October 9, 2007

**Re: Aircraft Hangar at Double Eagle II Airport, 7401 Paseo del Volcan NW,
Traffic Circulation Layout**

November 8, 2007

**Re: Aircraft Hanger, Double Eagle II Airport
Grading and Drainage Plan**

GRADING & DRAINAGE PLAN
1" = 20'-0"

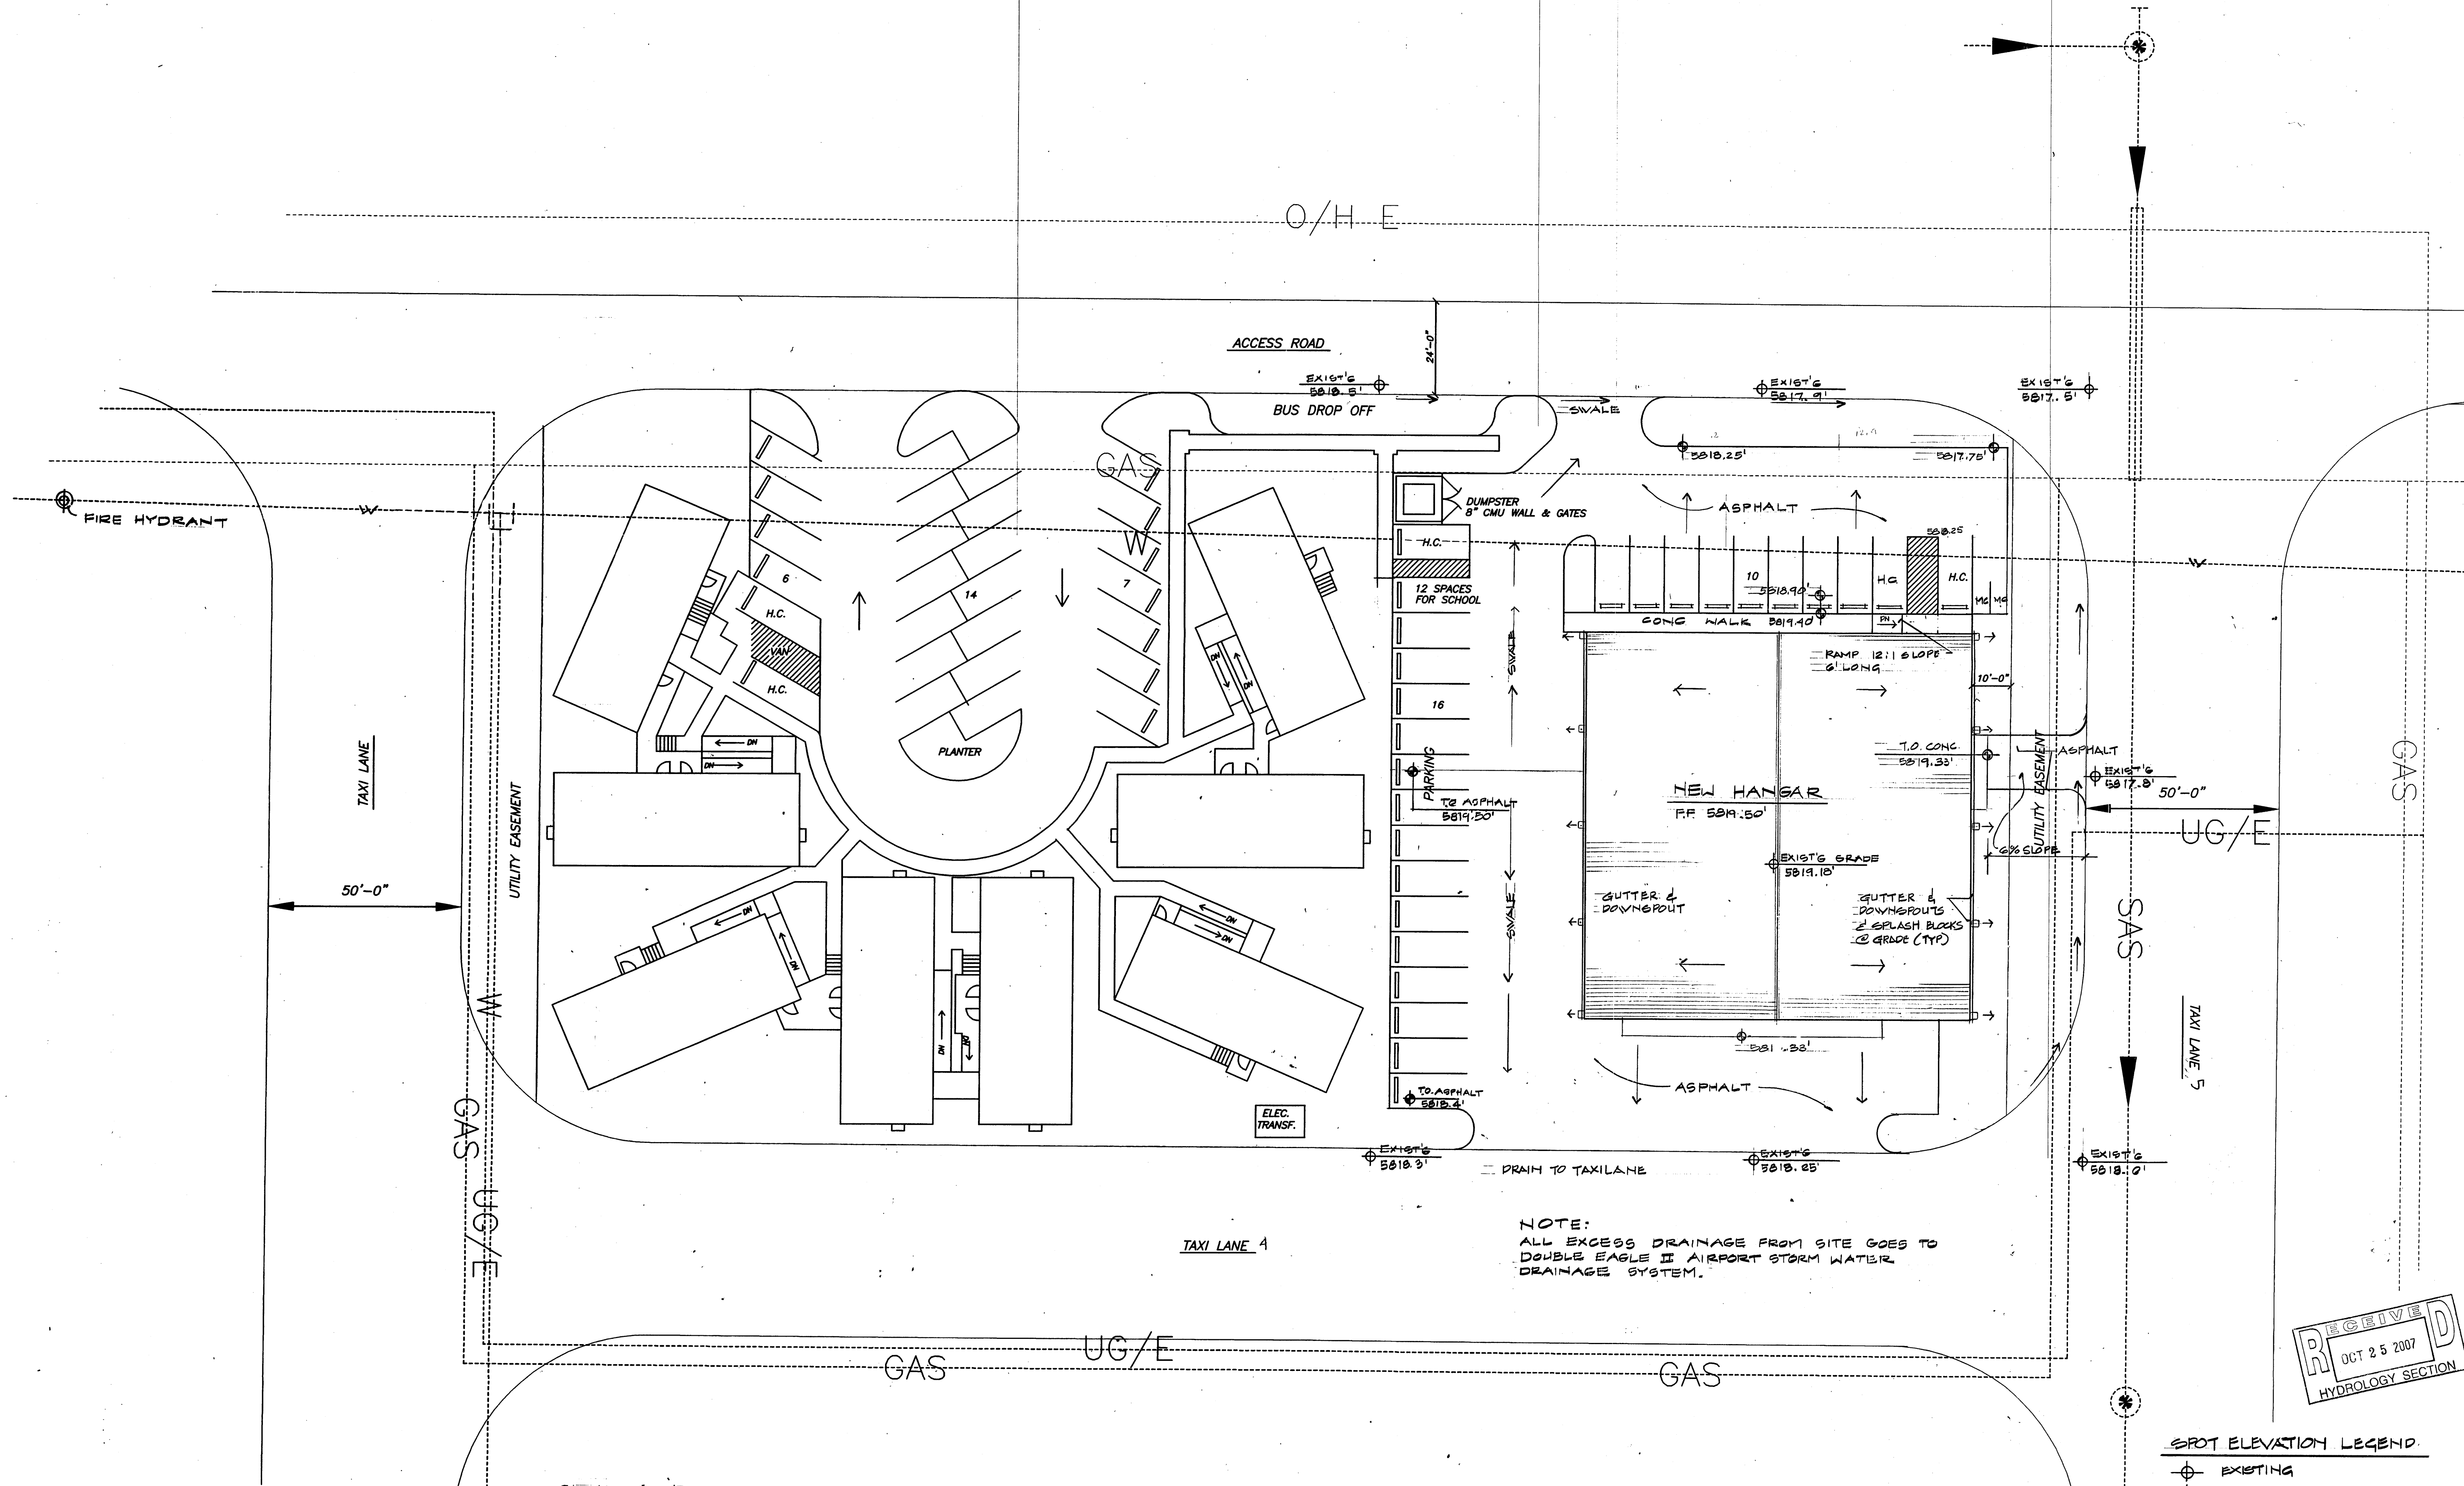
Based upon the information provided in your submittal received 10-25-07, the above referenced plan cannot be approved for Building Permit until the following comments are addressed:

1. The grading and Drainage plan must provide the necessary data according to the City of Albuquerque's Development Process Manual.
